HERTFORDSHIRE ECOLOGY

Application: Erection of a 3 storey building for B8 (storage and distribution) (4,878 sq metres) and B1 (office/light industrial) (1,550 sq metres) use, together with 100 car parking spaces, 10 cycle parking spaces, boundary treatment, landscaping, lighting and access. Amended details.

Address: Plot 5000, Hatfield Business Park, Hatfield, AL10 9EZ

Application No: 6/2017/0624/MAJ

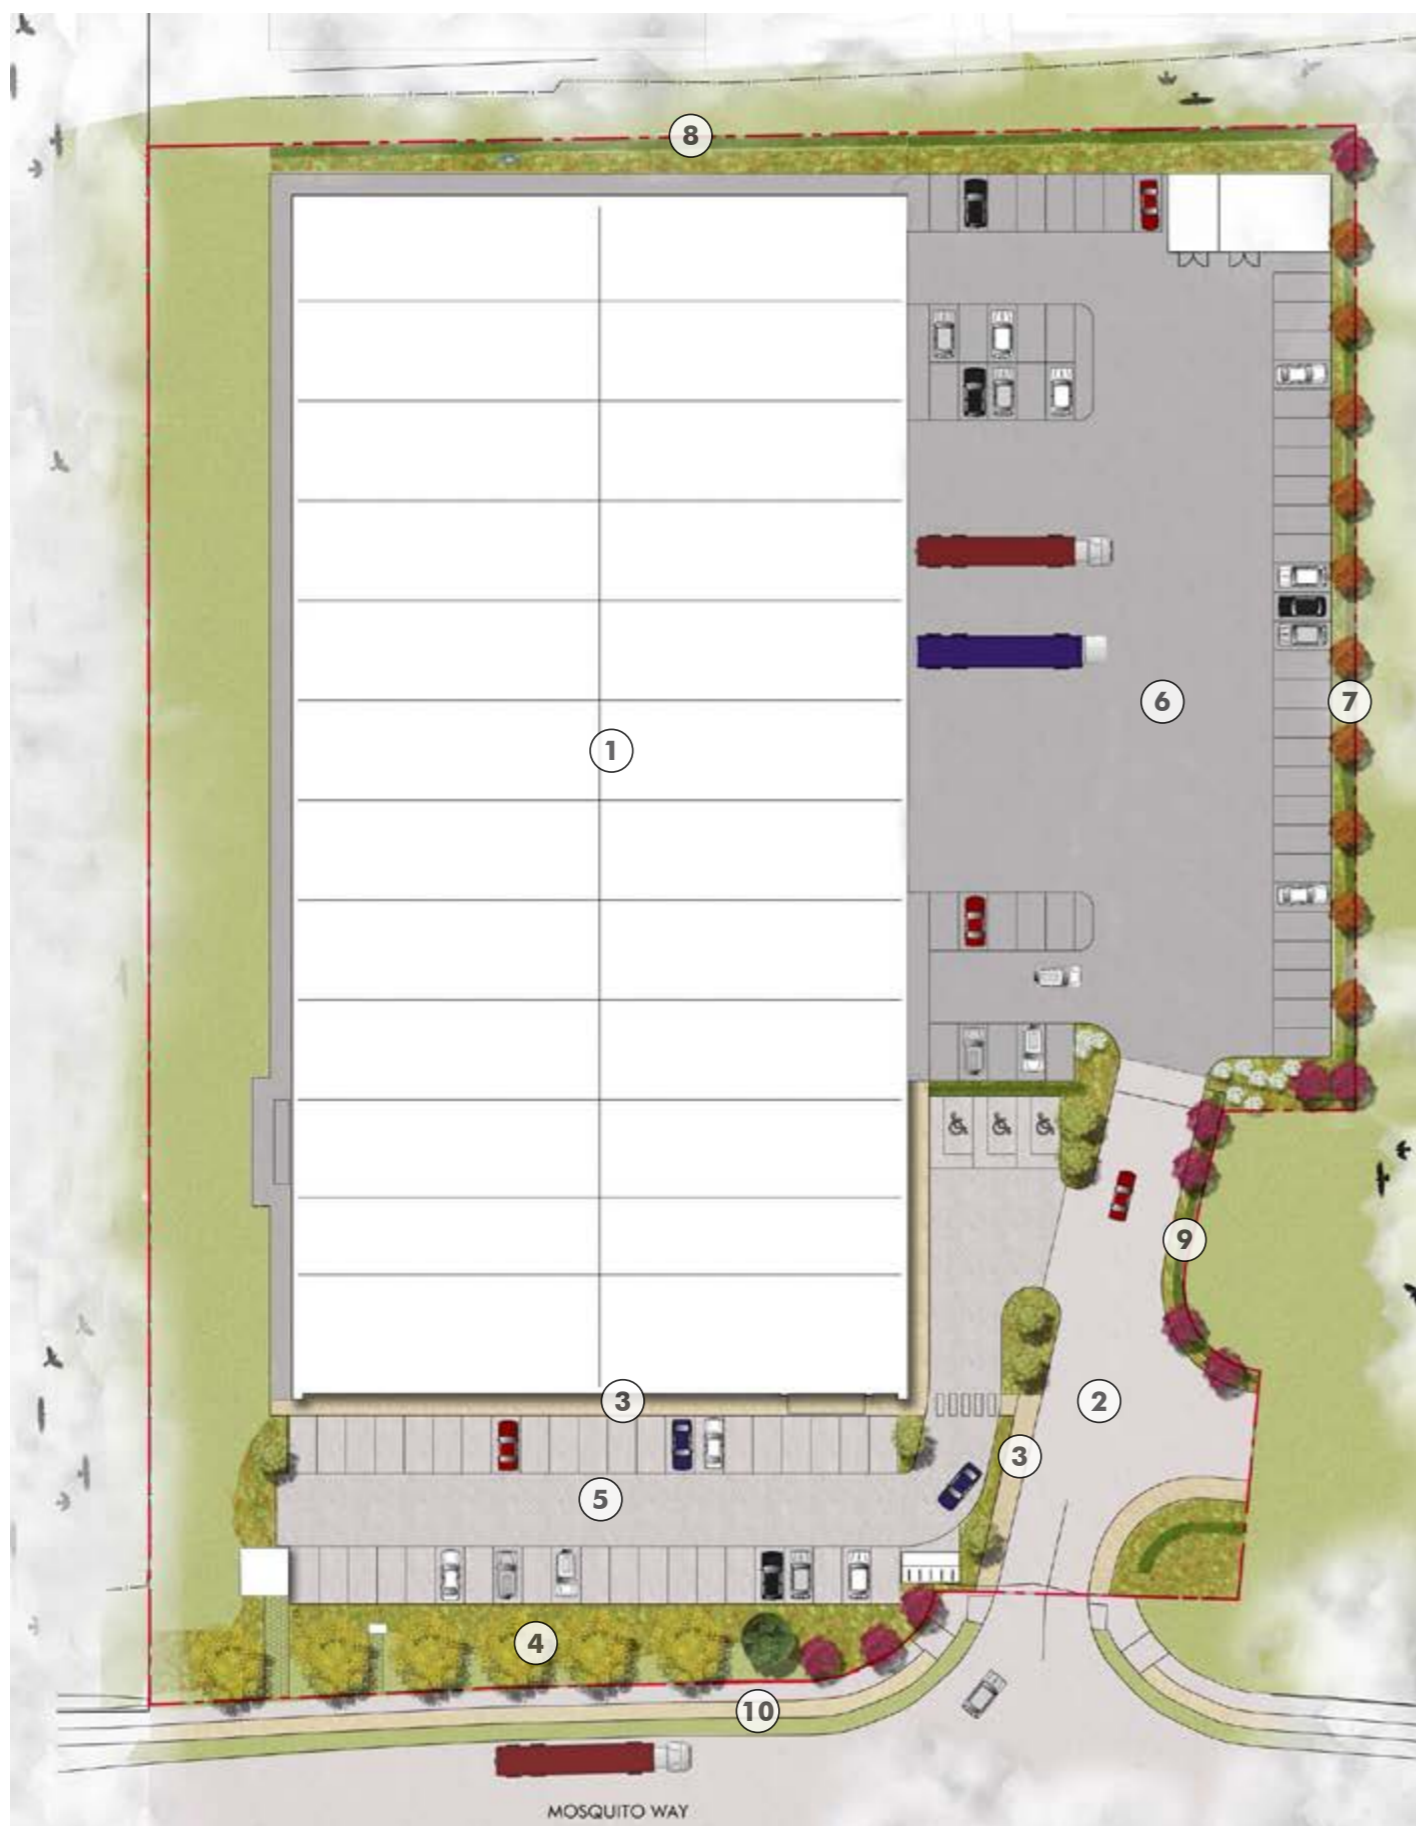
5. The meadow area and its management should also be included within Section 3.2 - the Illustrative Landscape Masterplan – currently this area is not defined in any way.
